Our ref: DOC19/779746
Senders ref: SSD 8194

Subject: Dendrobium Mine Extension Project – Review of EIS – SSD 8194

ATTACHMENT A: Environment, Energy & Science (EES) assessment summary for Dendrobium Mine Extension Project (SSD 8194)

ATTACHMENT B - Environment, Energy & Science (EES) - Biodiversity and Conservation Division detailed comments for Dendrobium Mine Extension Project (SSD 8194)

APPENDIX A – AREA 5 AND AREA 6 SWAMP MONITORING

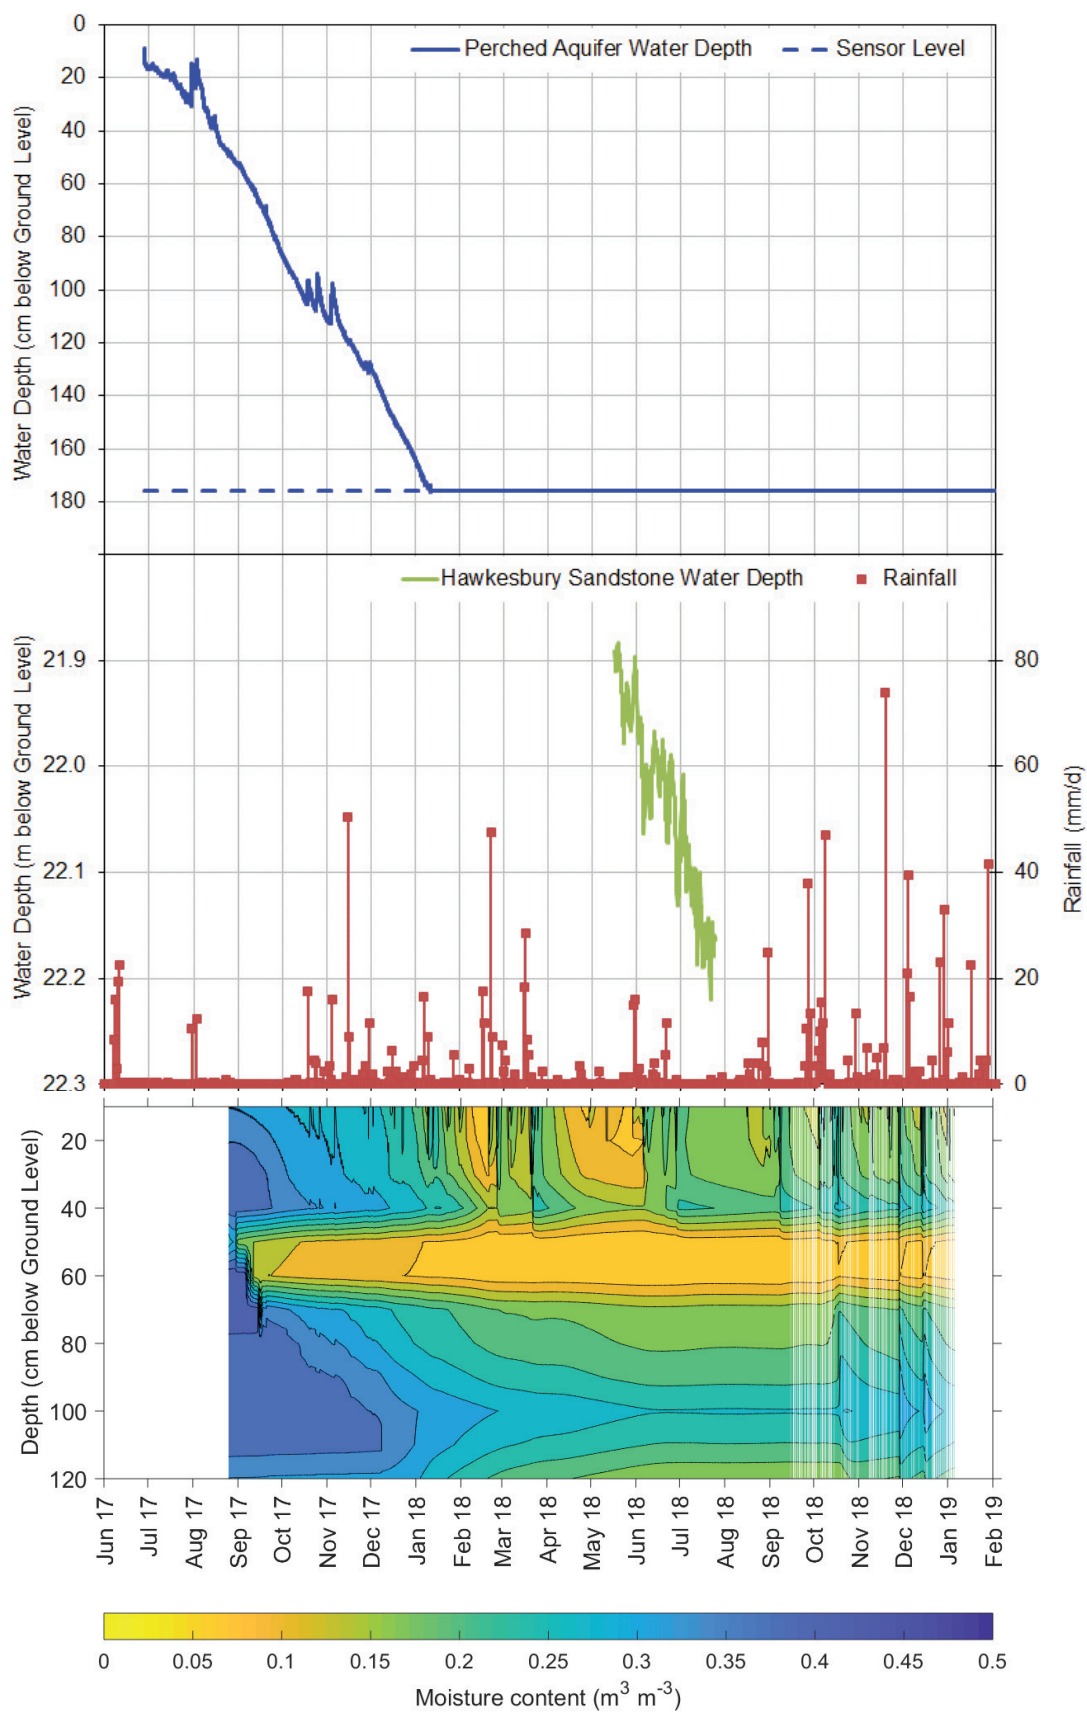
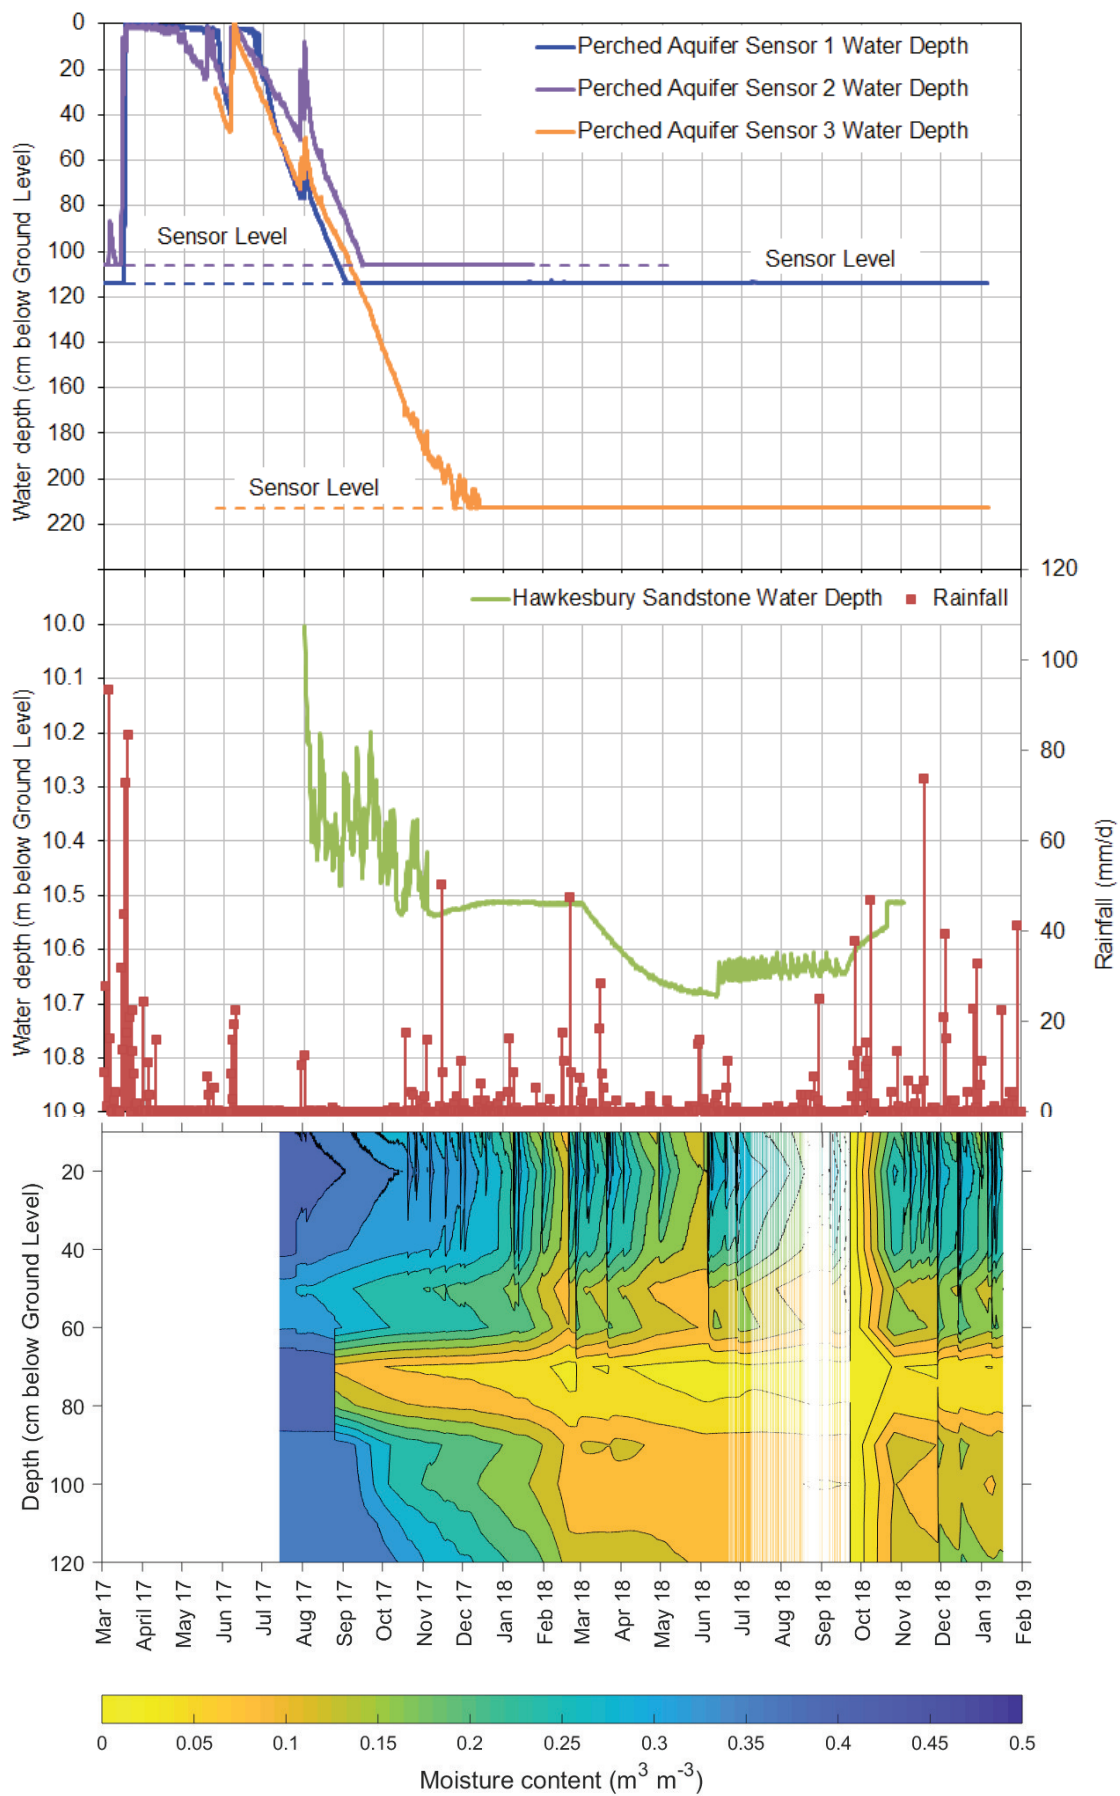
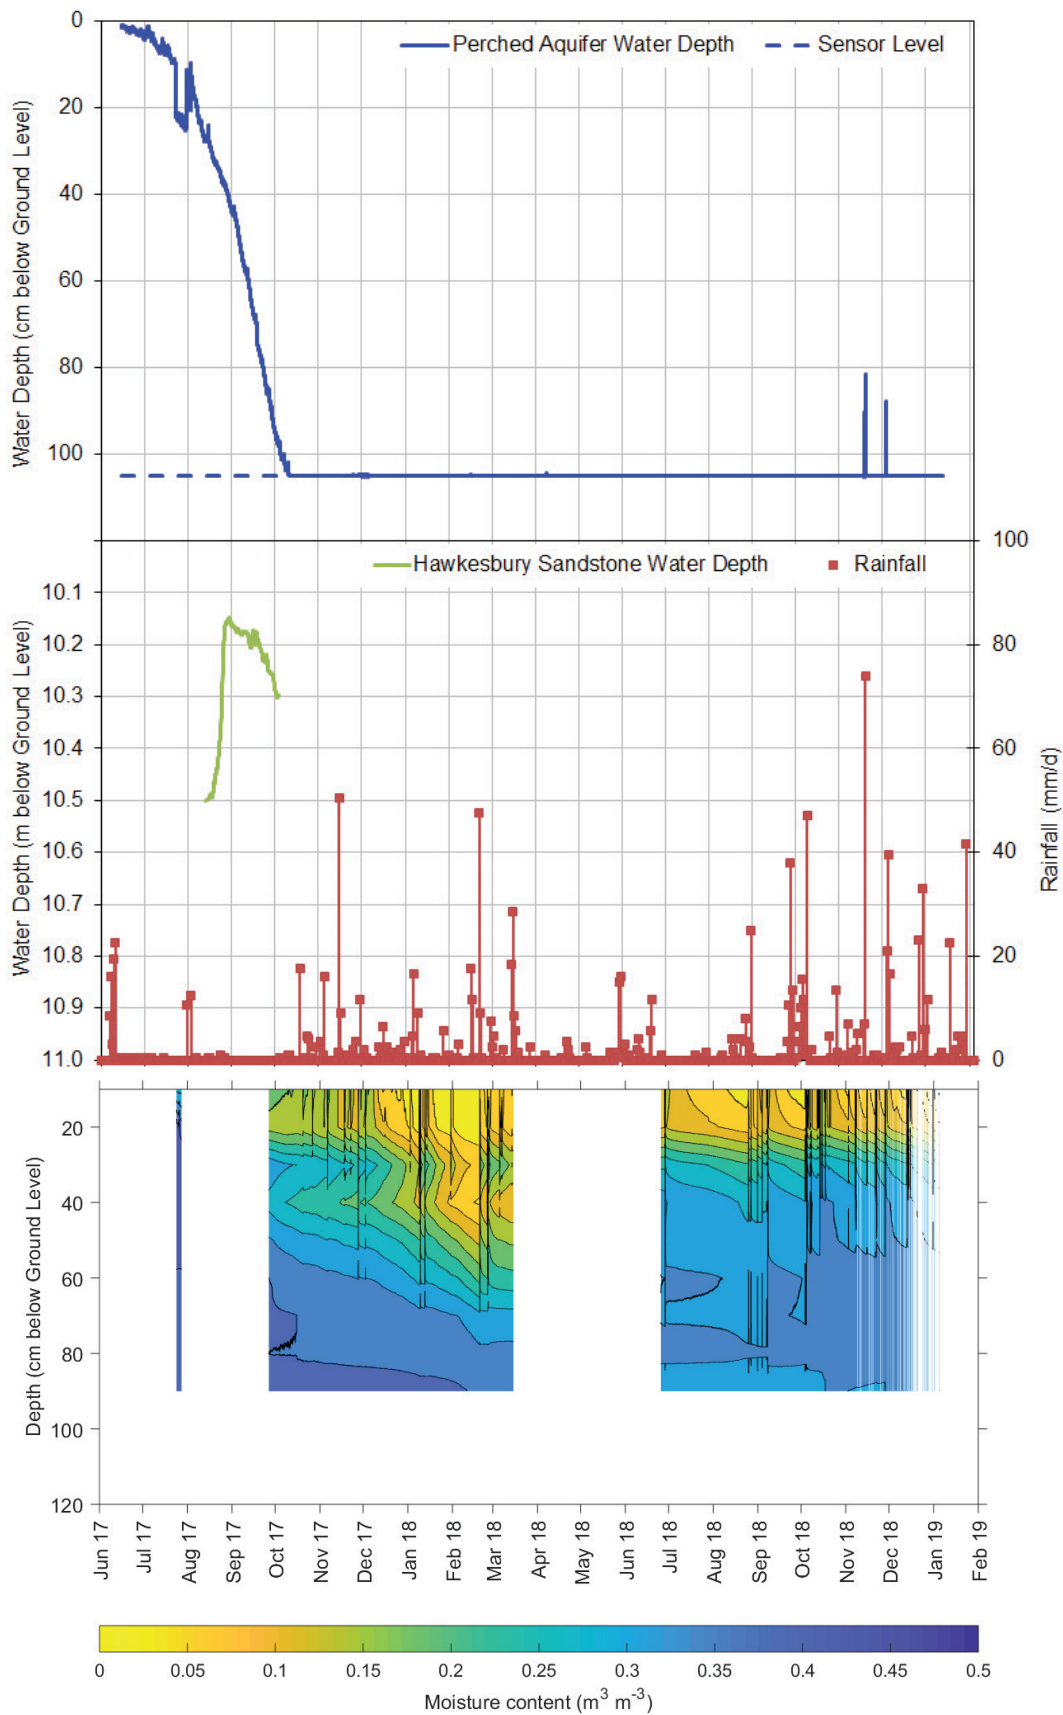
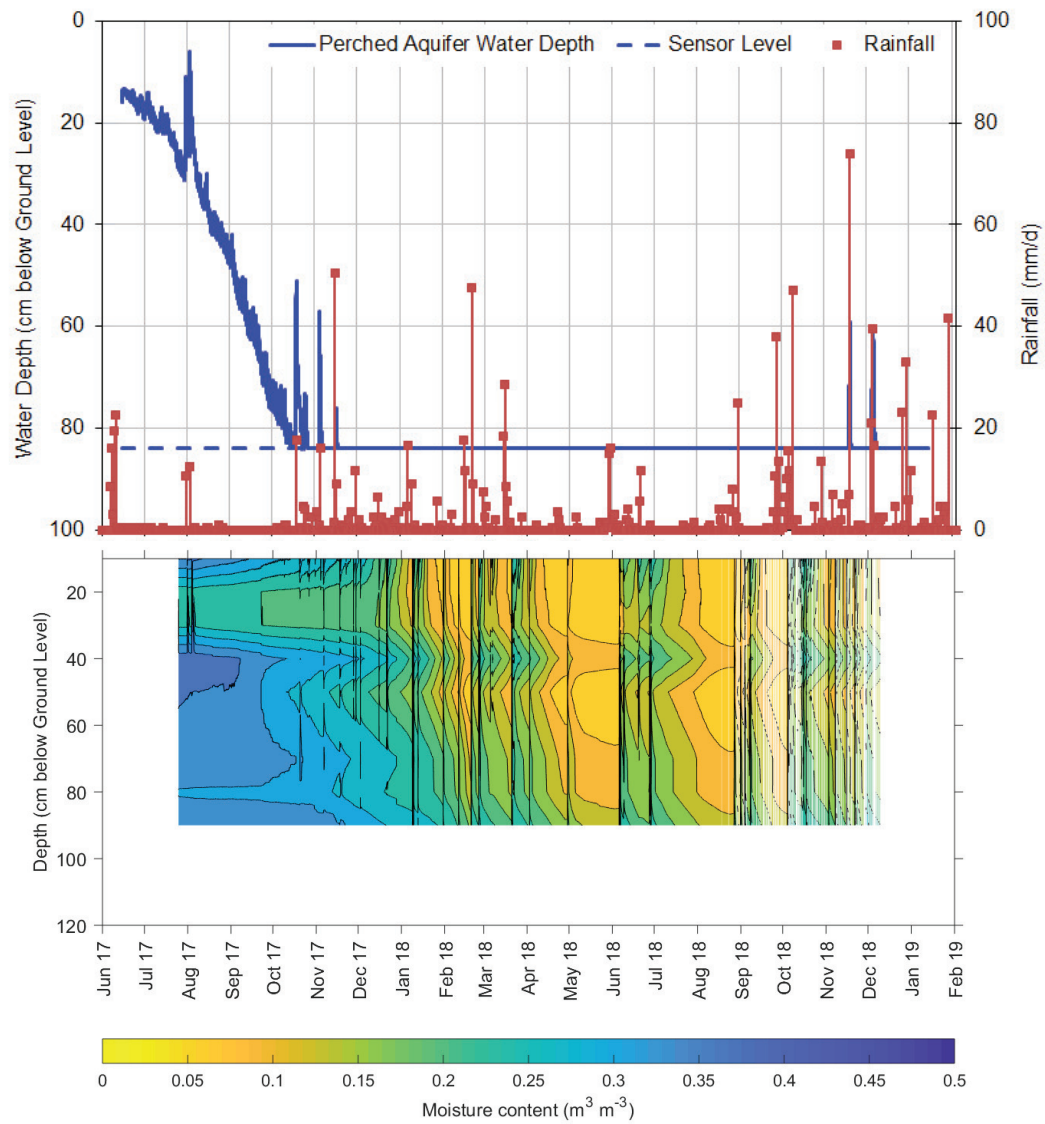
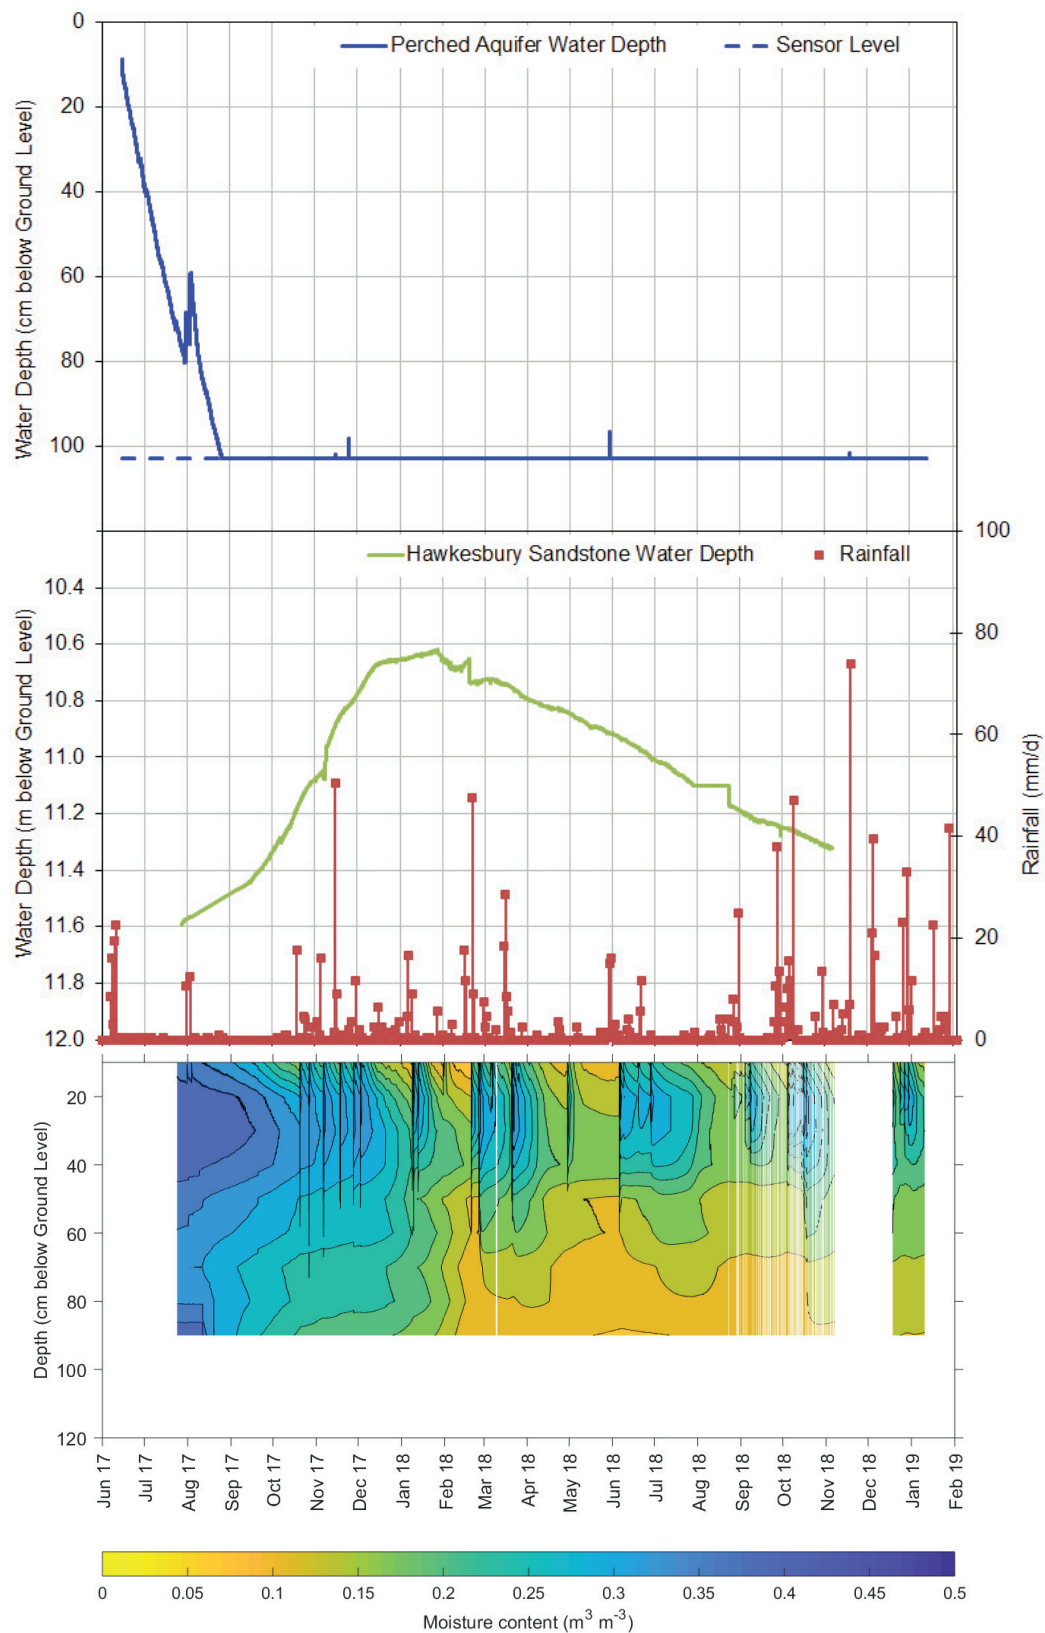
- The data that is used to characterise the shallow groundwater in the majority of monitored upland swamps in Areas 5 and 6 does not show a response in the groundwater level or soil moisture from a significant rainfall event. This raises doubt about the quality of data used to inform the upland swamp impact assessment and future monitoring of impacts from mining.

4	<i>Issue</i>	Peer review of upland swamp shallow groundwater monitoring data
	<i>Extent and Timing</i>	As soon as practicable
	<i>Recommended action</i>	<ul style="list-style-type: none"> We request access to all raw swamp monitoring data to review.
